Yorkshire Green Energy Enablement (GREEN) Project

**Document 8.28 Applicant's Comments on Interested Parties' Deadline
5 Submissions**

**Final Issue A
July 2023**

Planning Inspectorate Reference: EN020024

ECSEC  
AREA 1850m<sup>2</sup>  
49.949m AOD

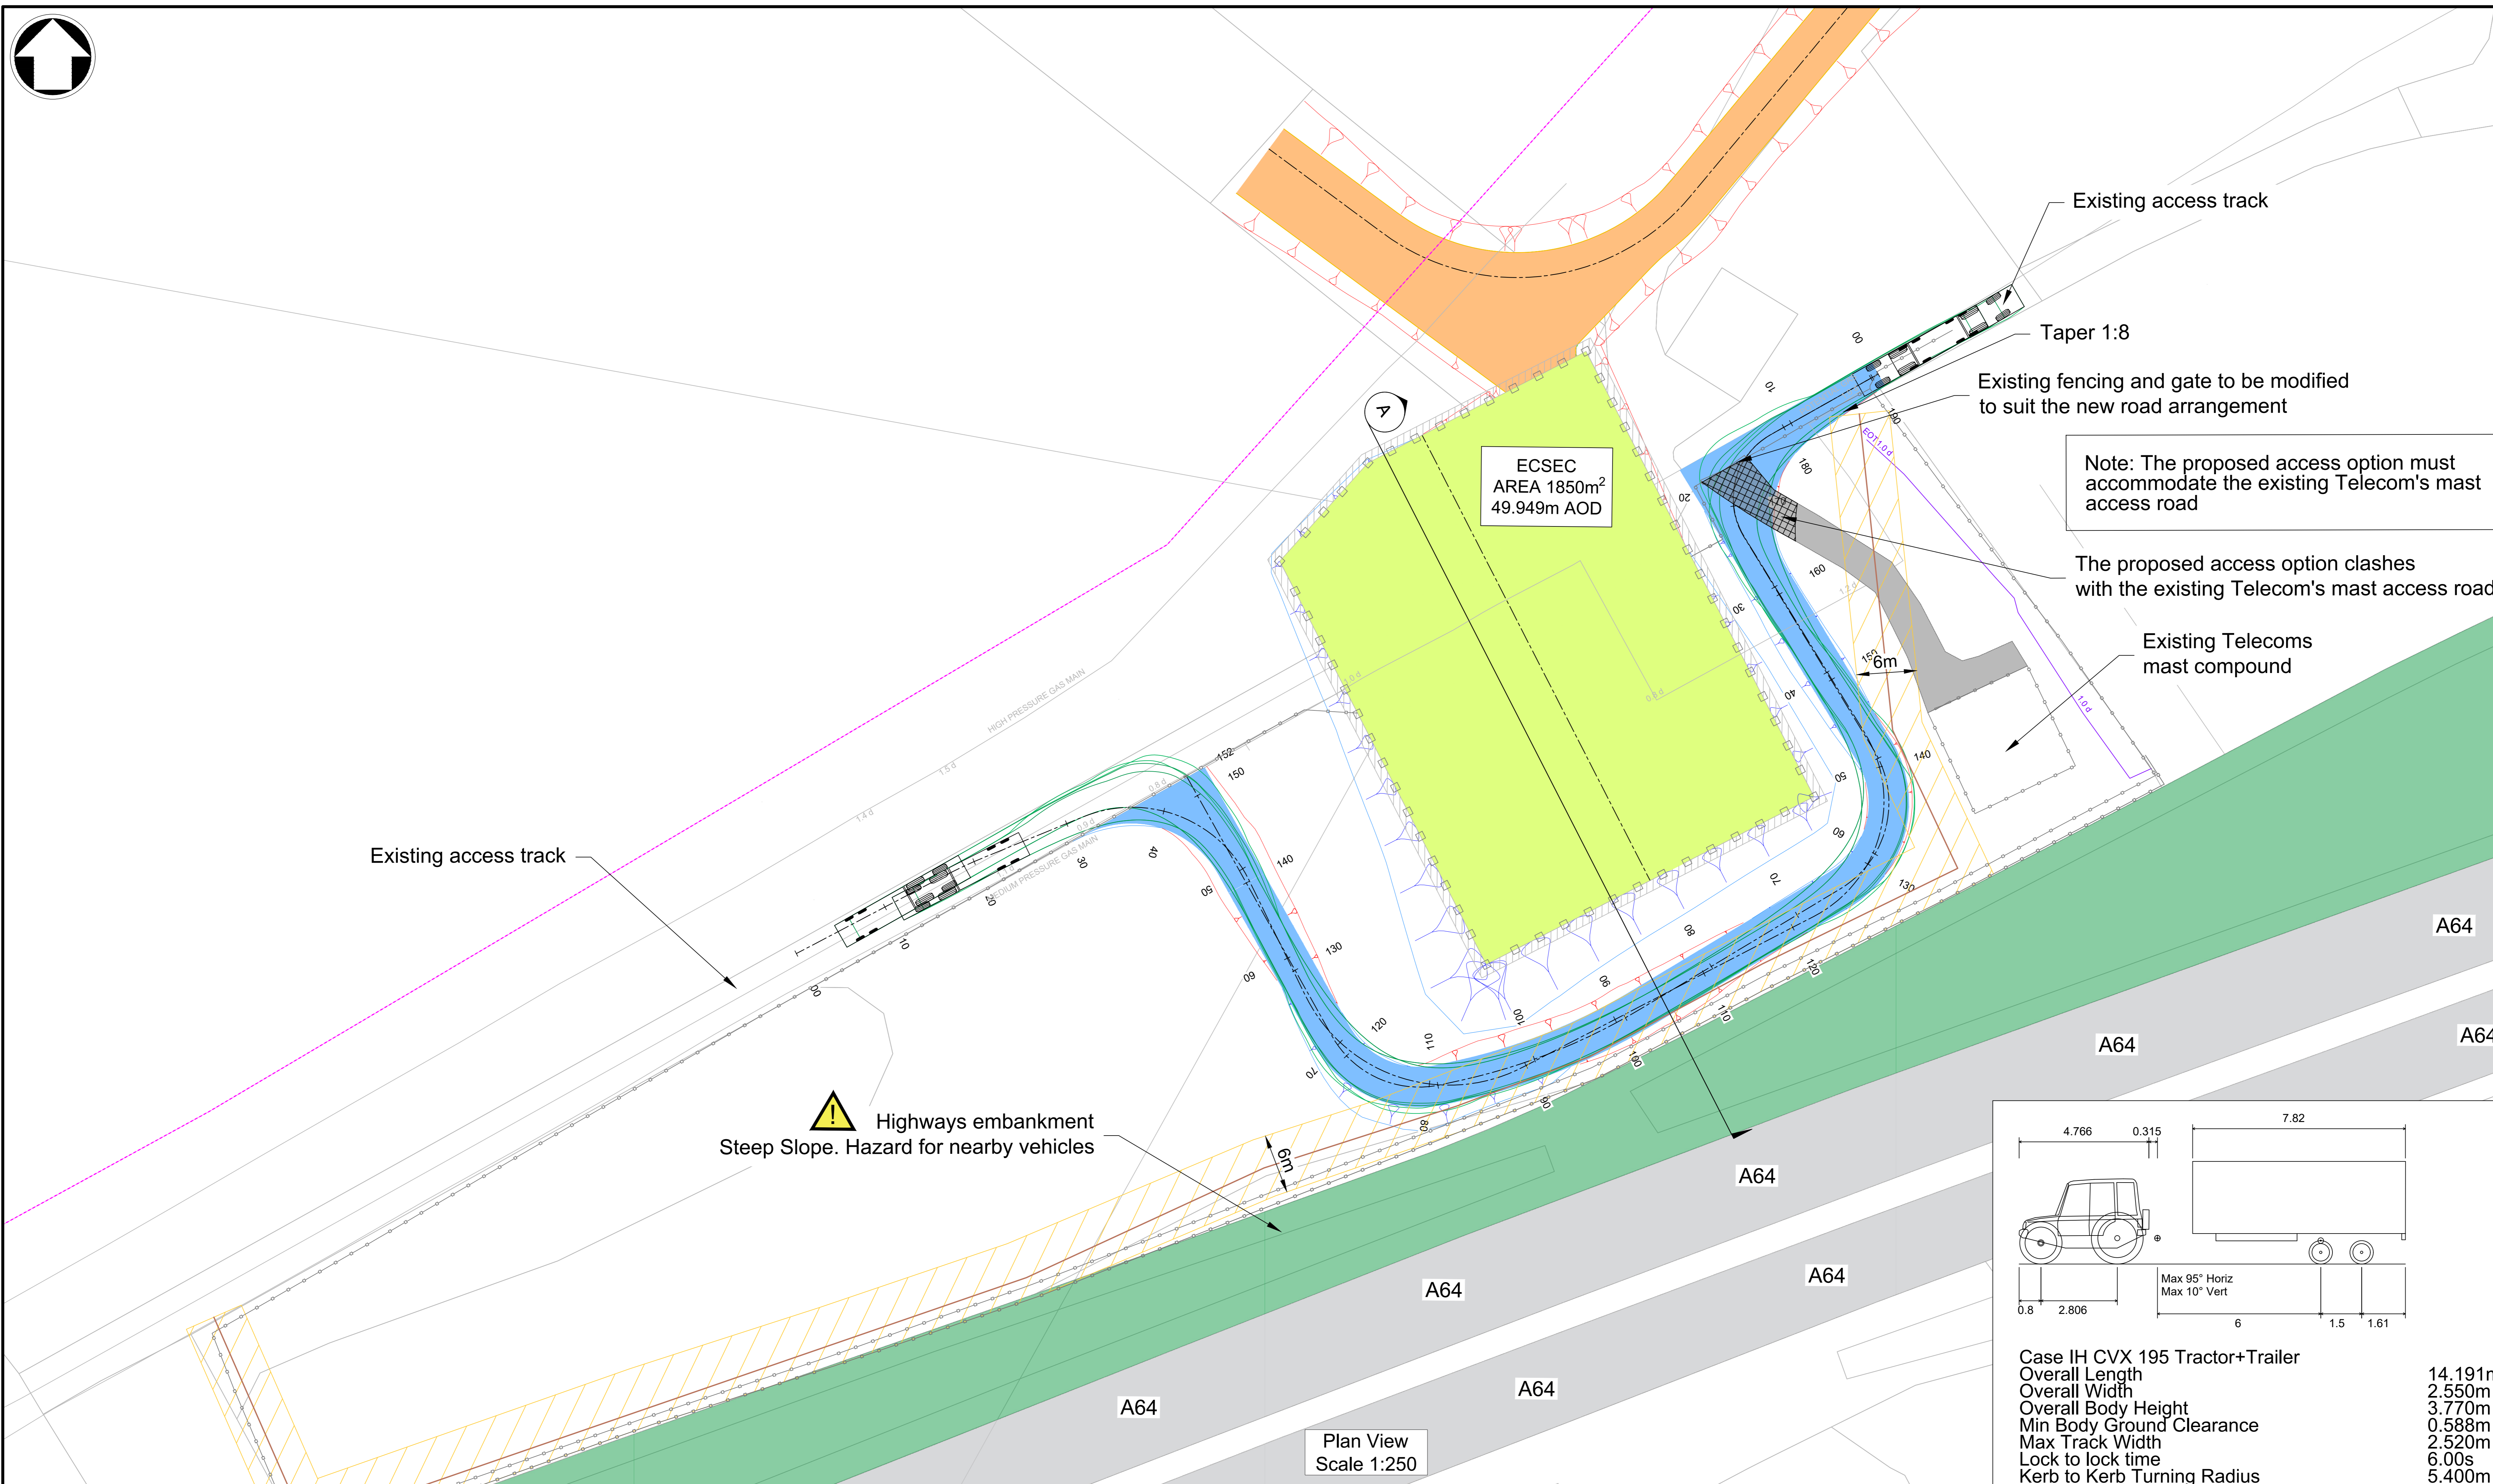
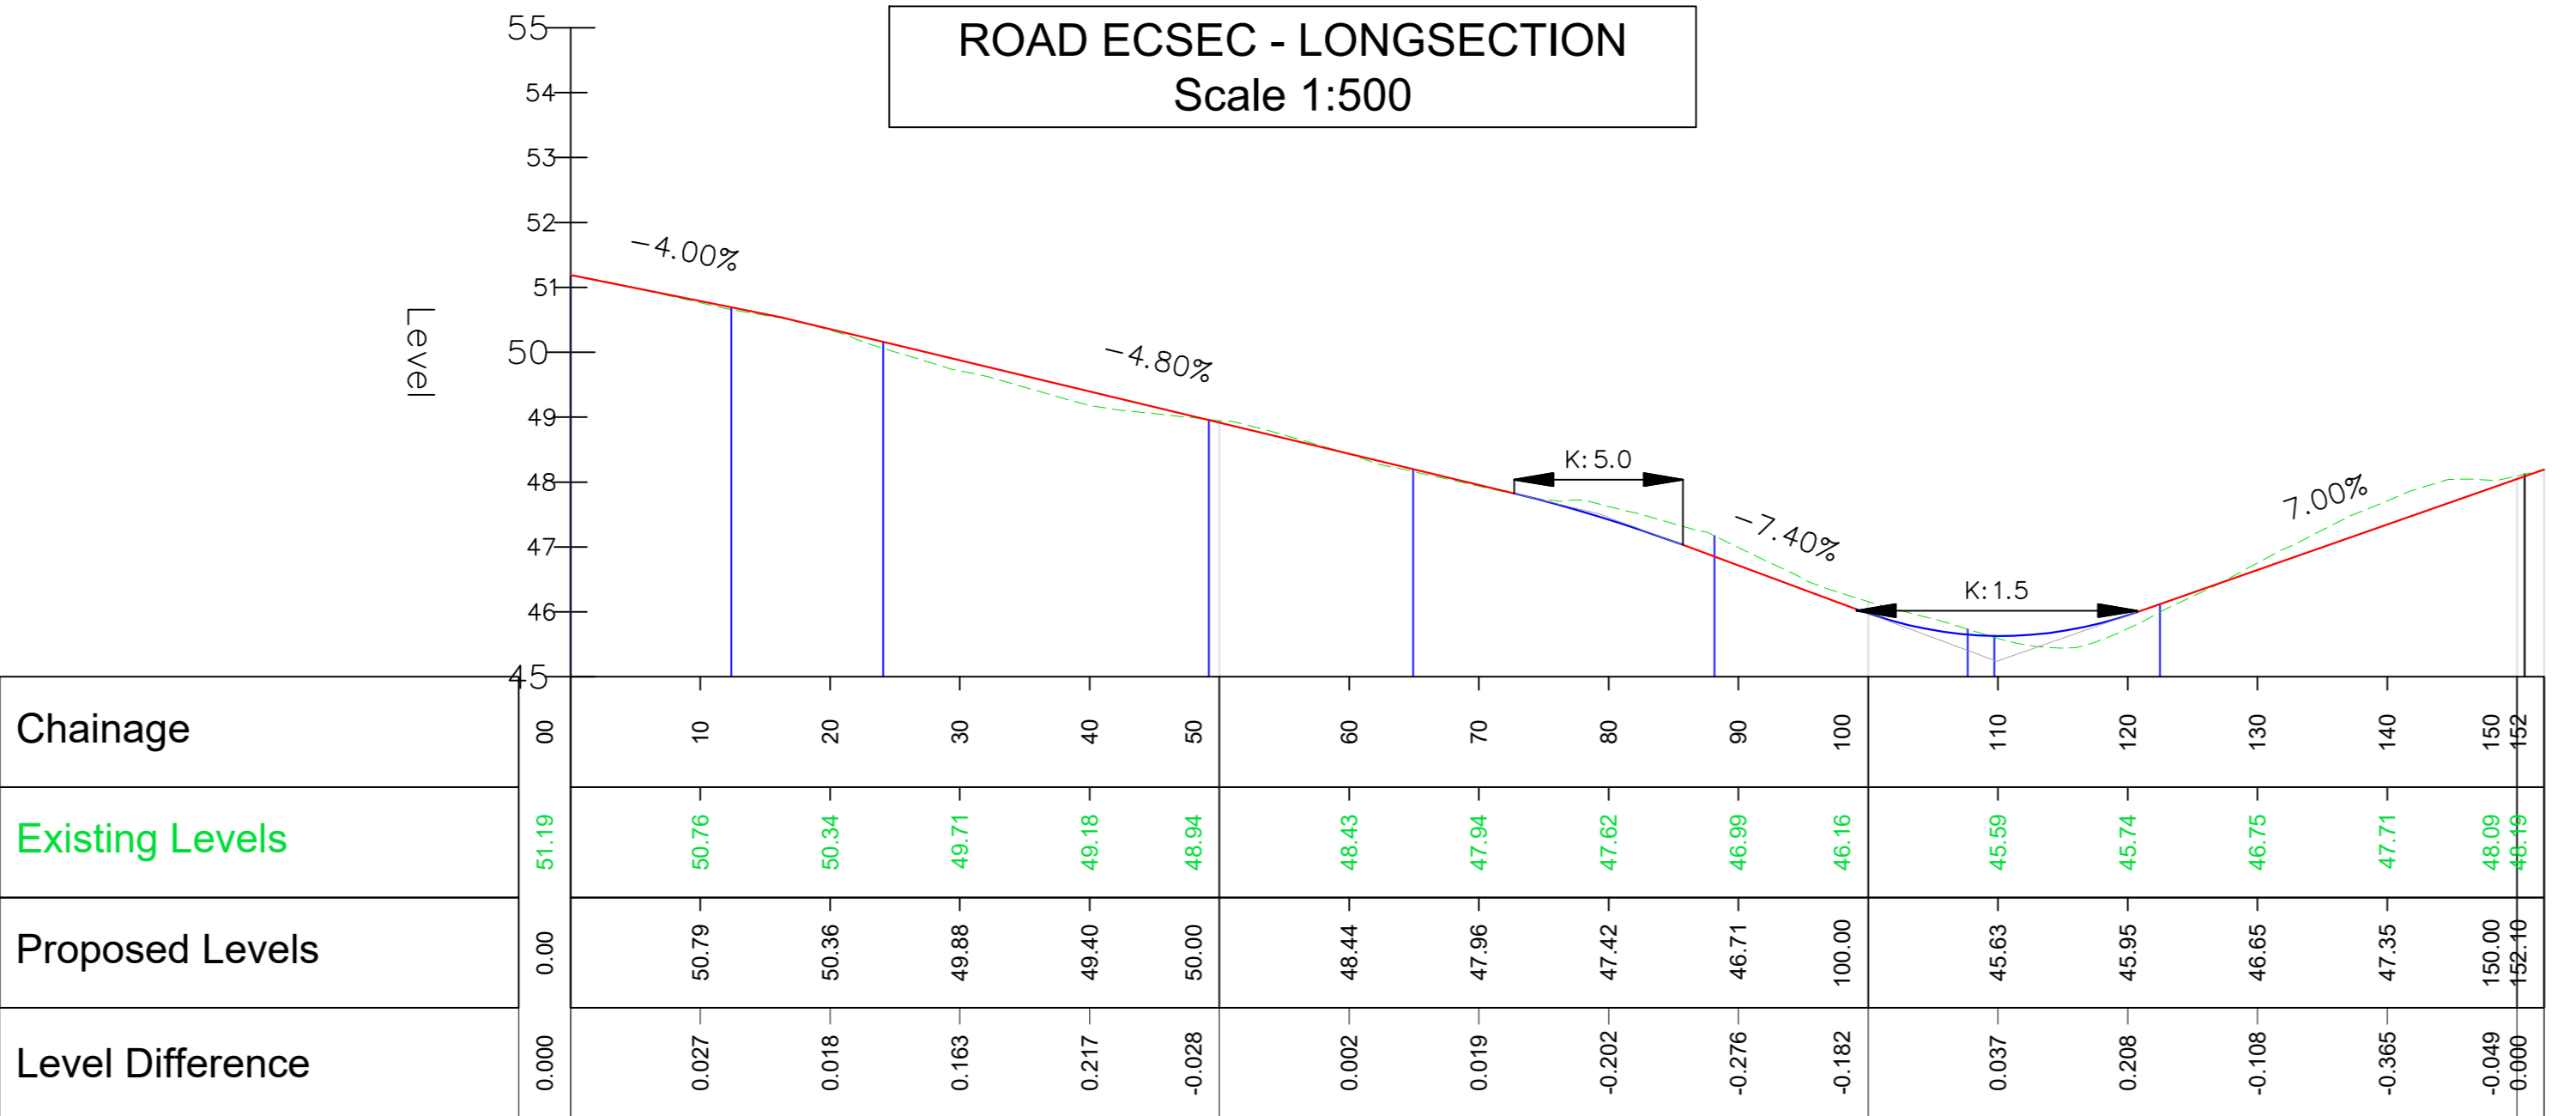
Reference	Topic	Applicant's Response
		<p>retaining wall would not be suitable solution for the use at Tadcaster East CSEC and is not proposed.</p> <p><u>Crop Planting and Access Arrangements</u></p> <p>Access to the landowners field would be maintained with a right granted across the permanent access to the CSEC. Furthermore, National Grid is able to provide a further access gate along the proposed permanent access road to the Tadcaster West CSEC that would enable access to the lower part of the field. This would enable two accesses to the field should two different crops be required to be planted.</p> <p><u>Tadcaster East CSEC – access rights</u></p> <p>The landowner has referenced narrative provided by National Grid in [REP1-015] Table 2.13, Point 13.5 in which National Grid state that <i>should the landowner wish to retain the land despite its restricted accessibility, then National Grid would be willing to agree not to proceed with the acquisition in this part of the Order limits.</i> This statement relates to land to the West of Tadcaster East CSEC and was clear in its intention that this land would have restricted accessibility as National Grid are not proposing any access to this parcel of land. National Grid have included land plot D1-15 as compulsory acquisition as shown on the Land Plan Section D (Document 2.5.4(C)).</p> <p><u>Tadcaster West CSEC Access</u></p> <p>National Grid requires unrestricted access for the operation and maintenance of the cable sealing end compound, and to that extent would need to ensure that fly tipping and unauthorised parking in the bellmouth be prevented at all</p>
